STERLING RANCH EAST

PLATTING SUMMARY

V1_VicinityLocation Map review 1.pdf Markup Summary 2-16-2023

WILL BE EXCLUDED FROM STERLING RANCH METROPOLITAN DISTRICT NO. 2.

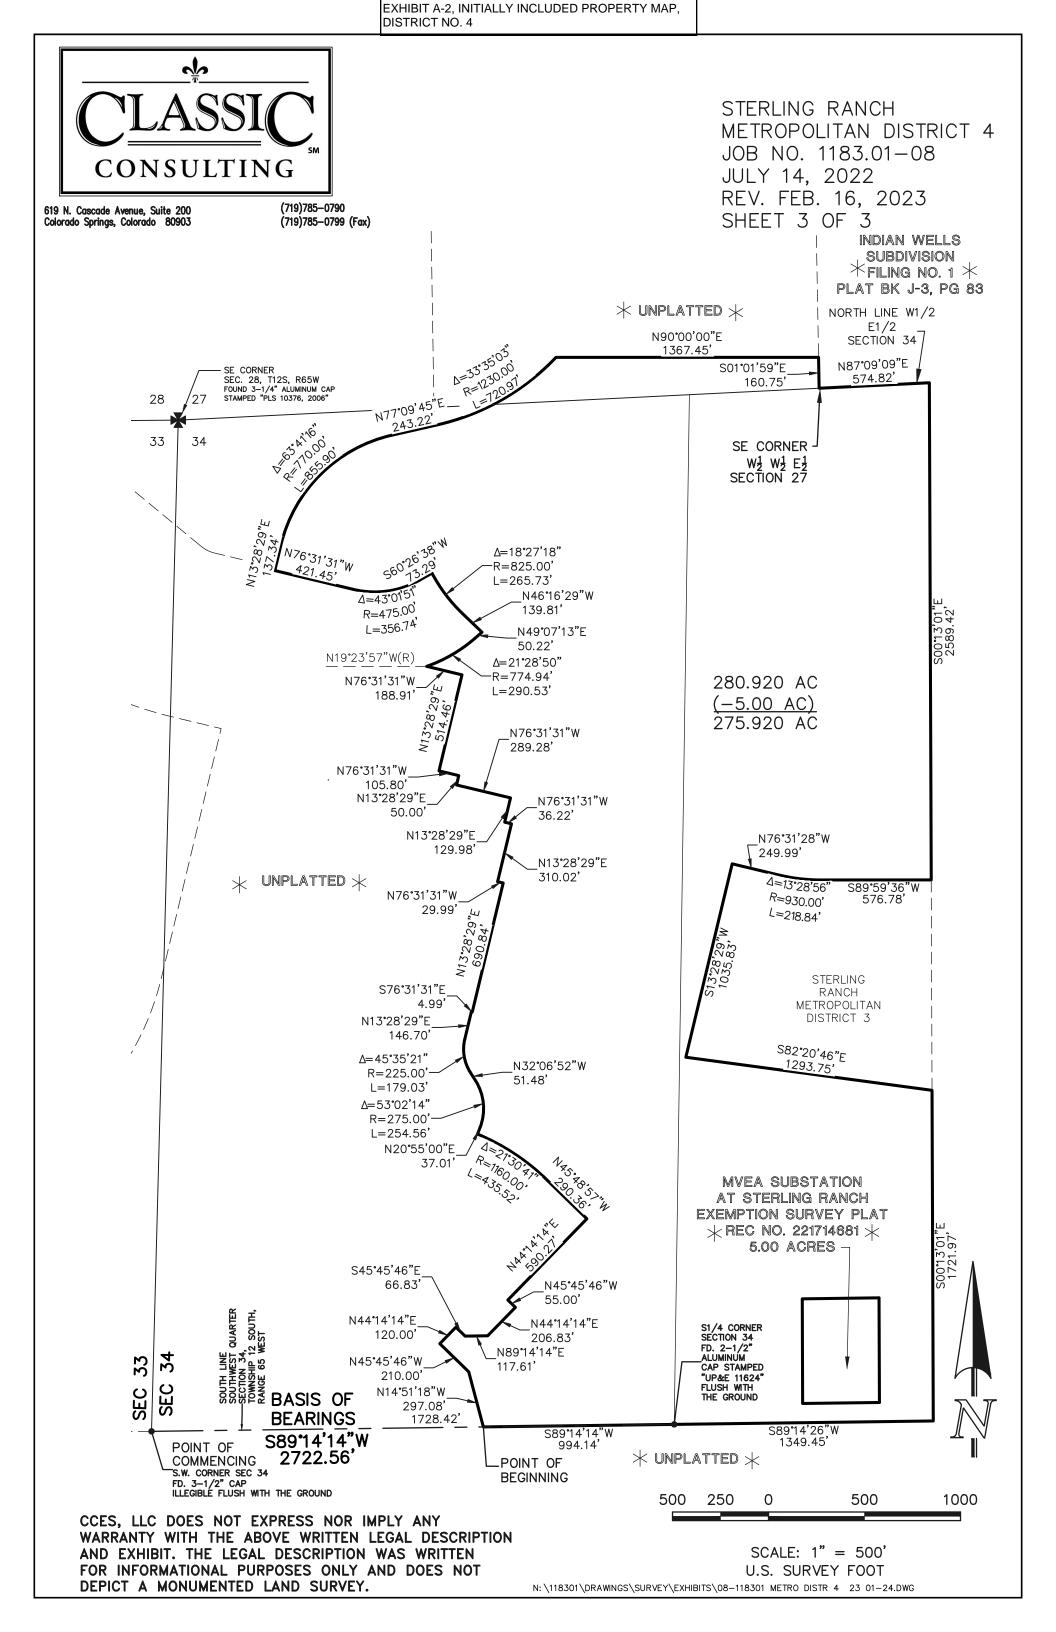
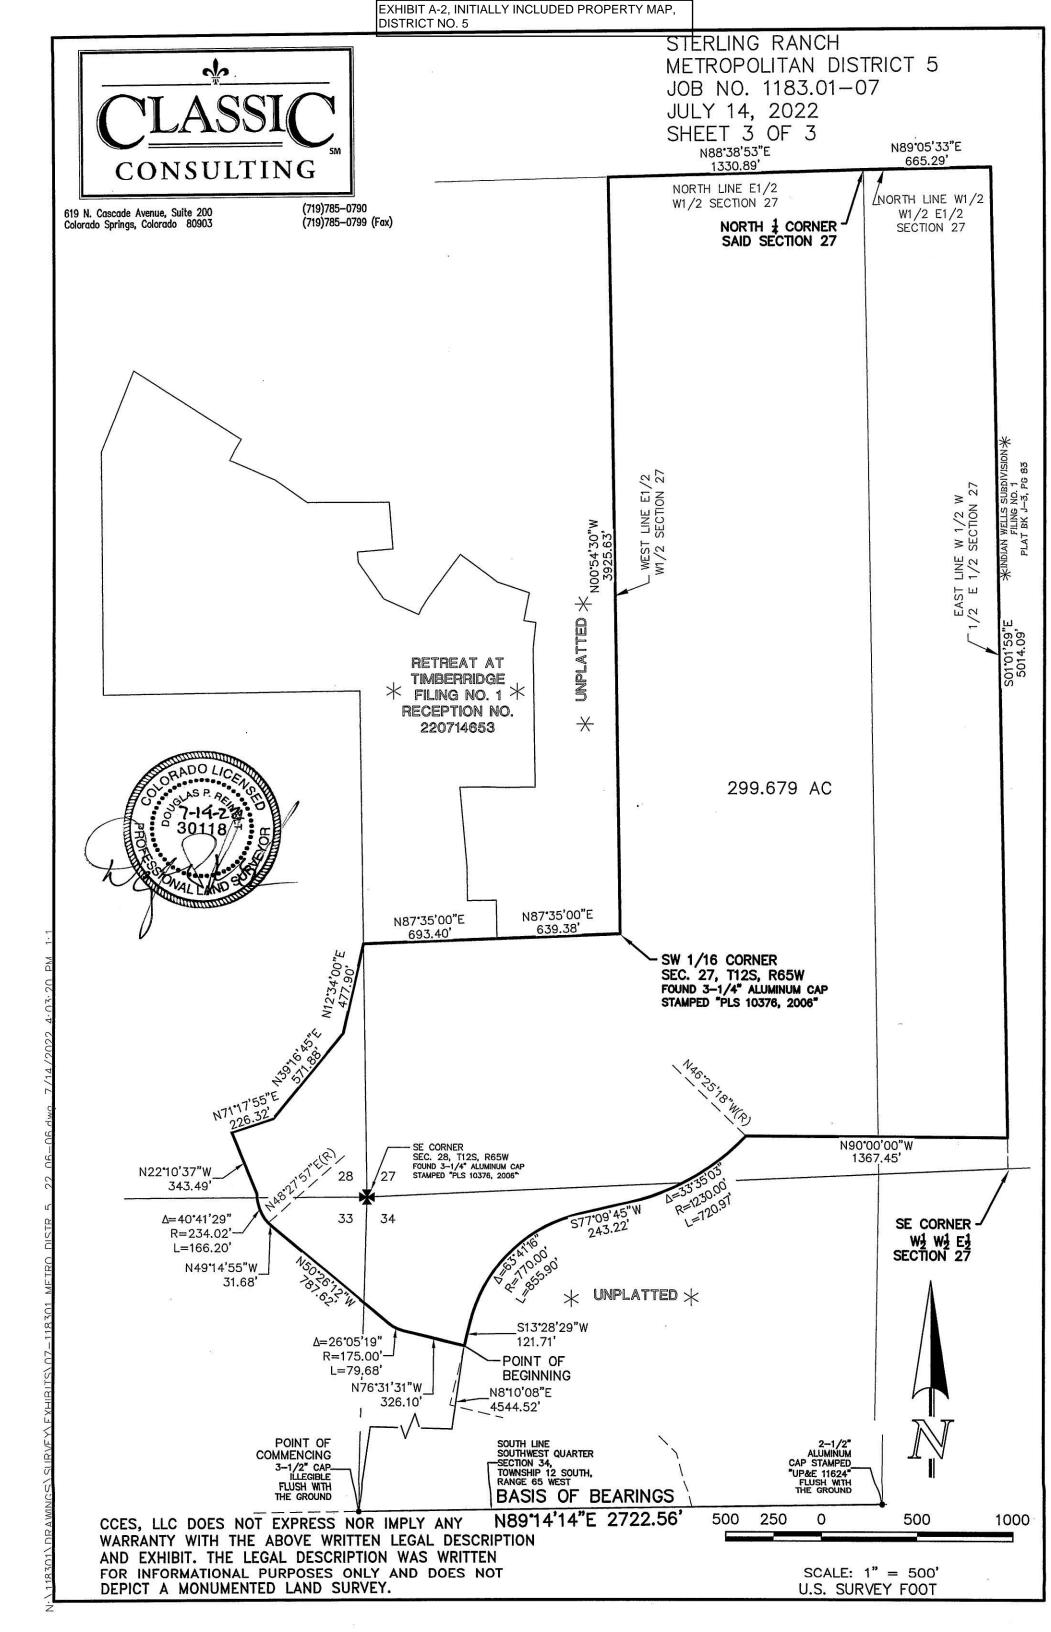
there are lots that encumber both (Existing and proposed) districts; perhaps the roads should be the district lines. Can the impacted lots be removed from existing district administratively by District Board? The taxation on the lots with multiple districts may be a challenge.

label the adjacent existing districts please
